CONSULTATION UNDER TOWN AND COUNTRY PLANNING ACT 1990

Application Number	PL/2022/00458/PPFL
Address	Arbour Tree Farm, Warwick Road, Knowle, Solihull.
Proposal	Conversion of existing farmhouse into four dwellings and the conversion and alteration of two existing agricultural barns into four dwellings
Case Officer	Ian Hiscock

Date comments sent	05th April 2022
Name of consultee department	Highways
Consultation response author	Ben Malin CMILT MCIHT

Appendix B

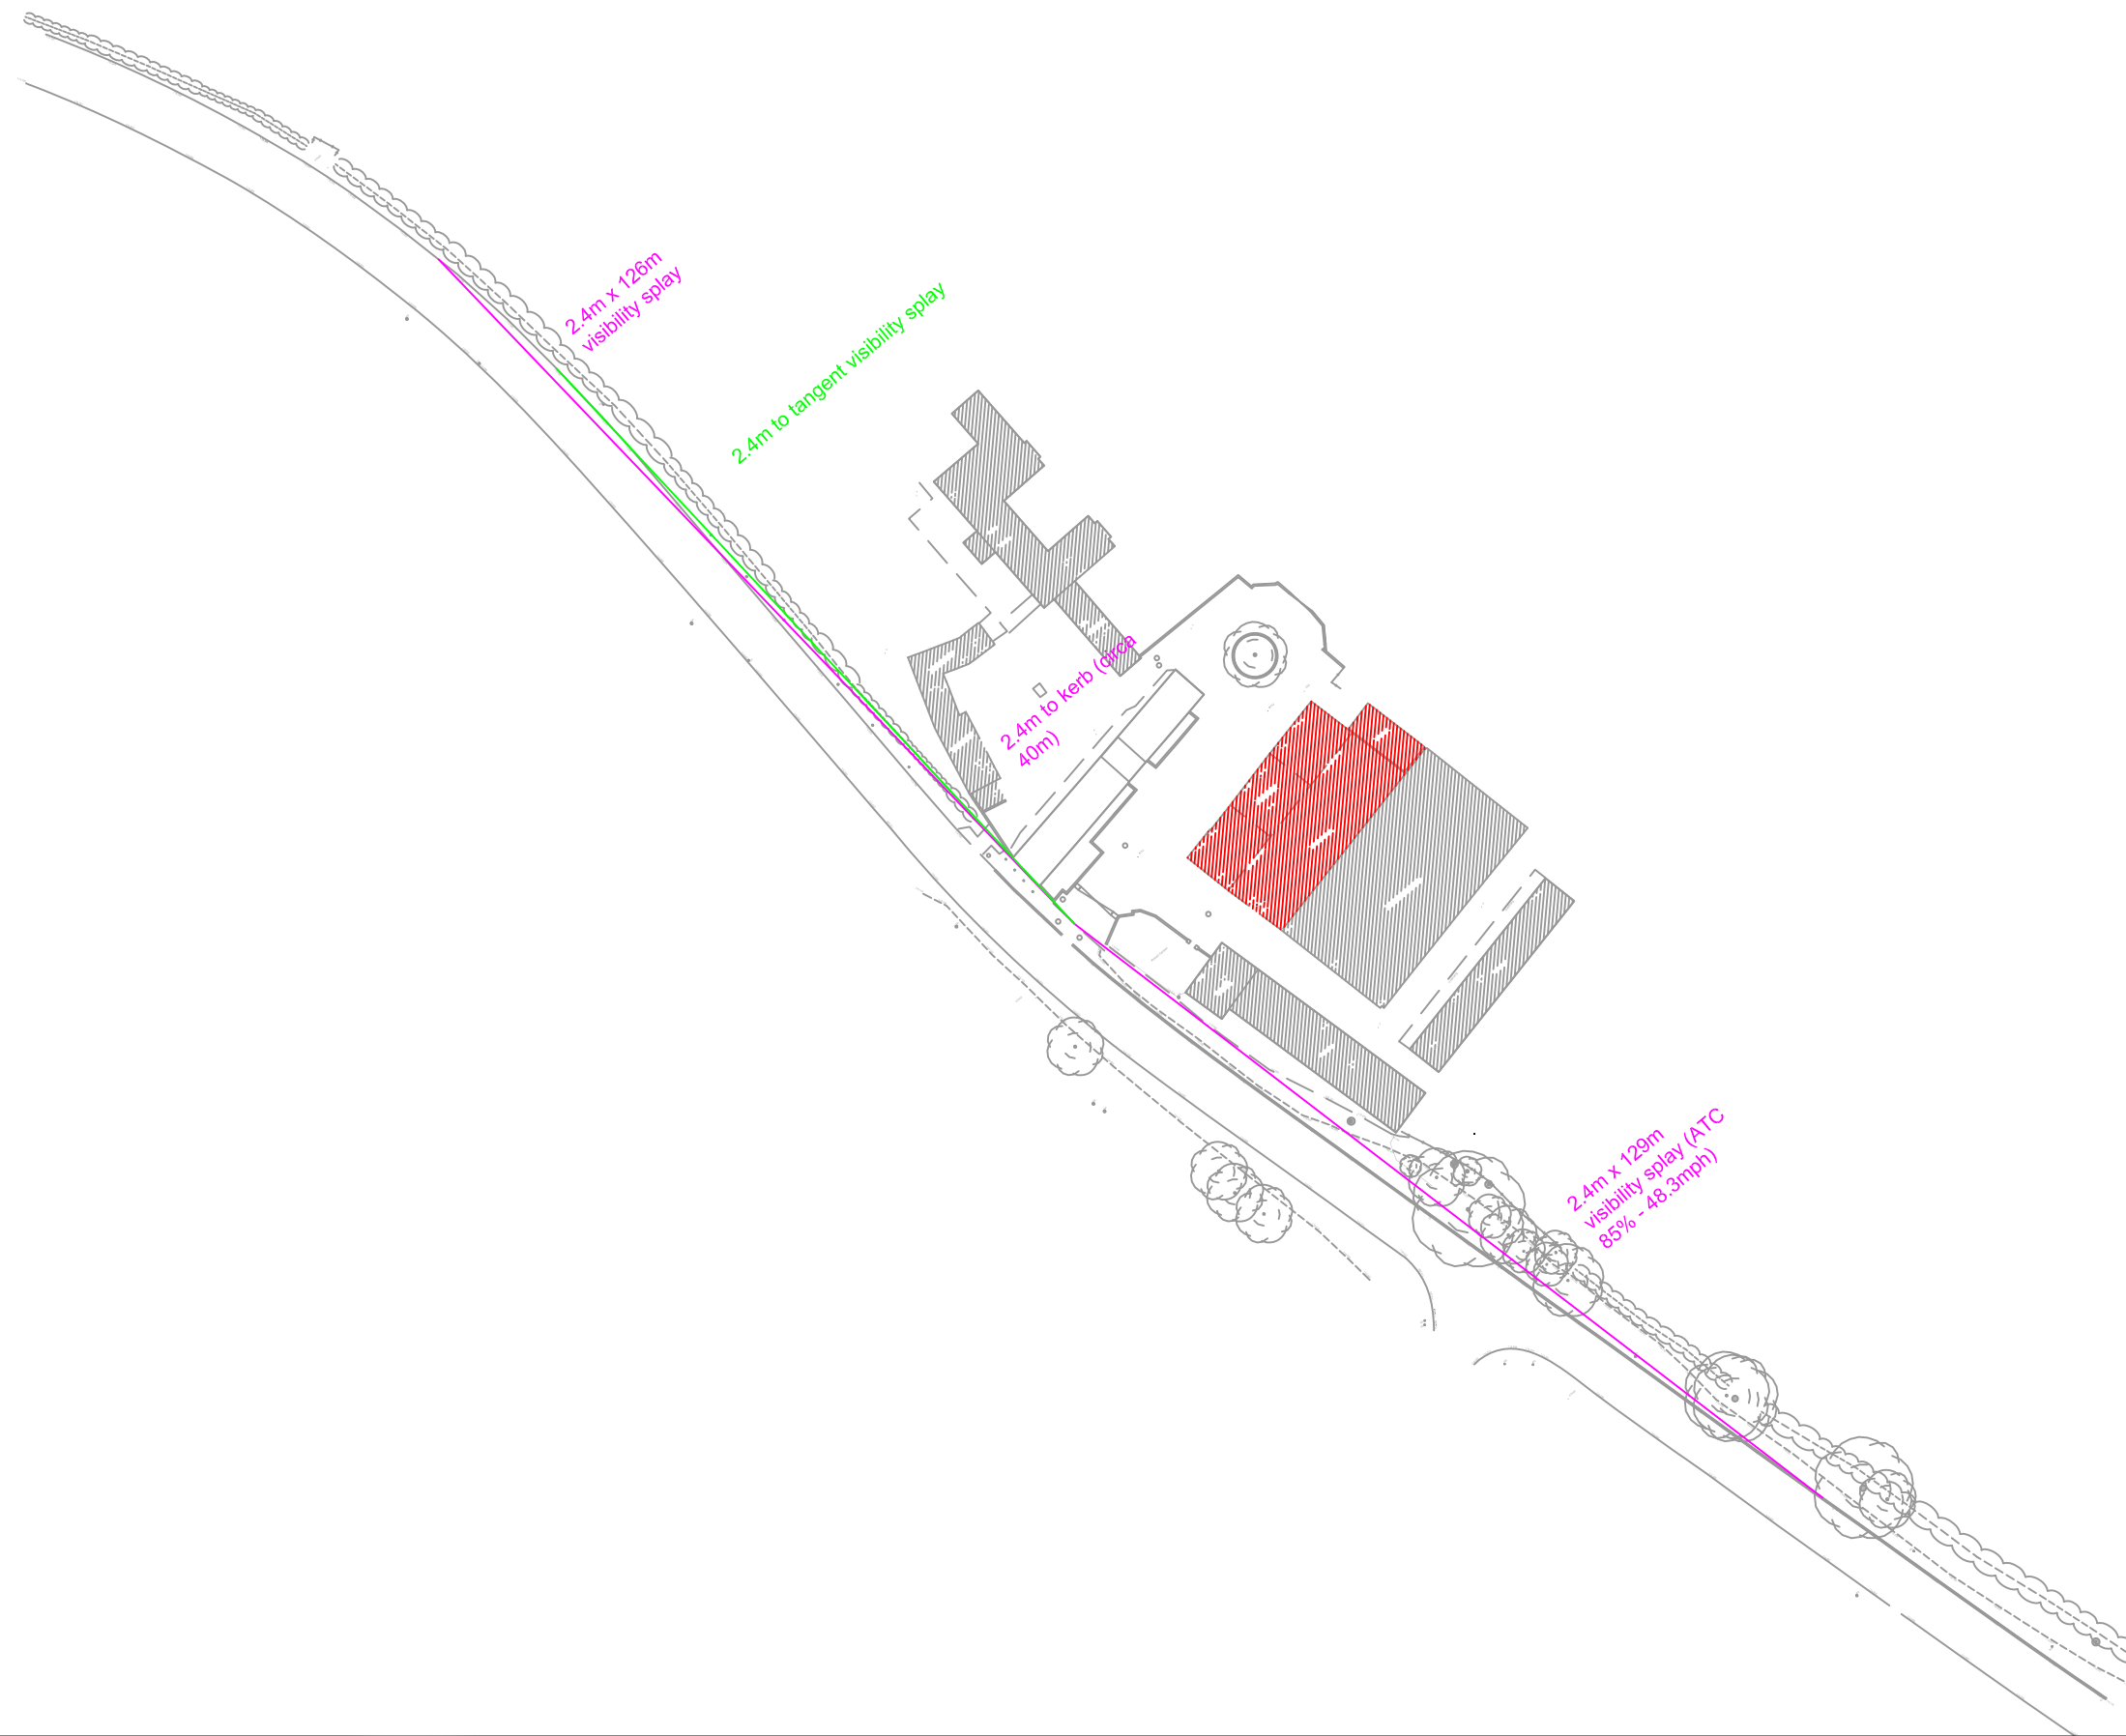
The existing vehicular access off Warwick Road (A4141) will be utilised to serve the proposed dwellings. An Access Note prepared by David Tucker Associates (DTA) on behalf of the applicant has been submitted in support of the proposals. The Access Note provides details of an Automatic Traffic Count (ATC) survey that was carried out in January 2020, which indicated that the 85thile speed of vehicles recorded along Warwick Road within the vicinity of the application site were 47.8mph for vehicles travelling southbound, and 48.3mph for vehicles travelling northbound. Visibility

splays commensurate with the 85th percentile speed of vehicles recorded have been illustrated on Drawing Number 22018-02 (Access Visibility Splays), as provided within Appendix B of the Access Note. The vehicular access is considered to be suitable to accommodate two-way vehicle movements.
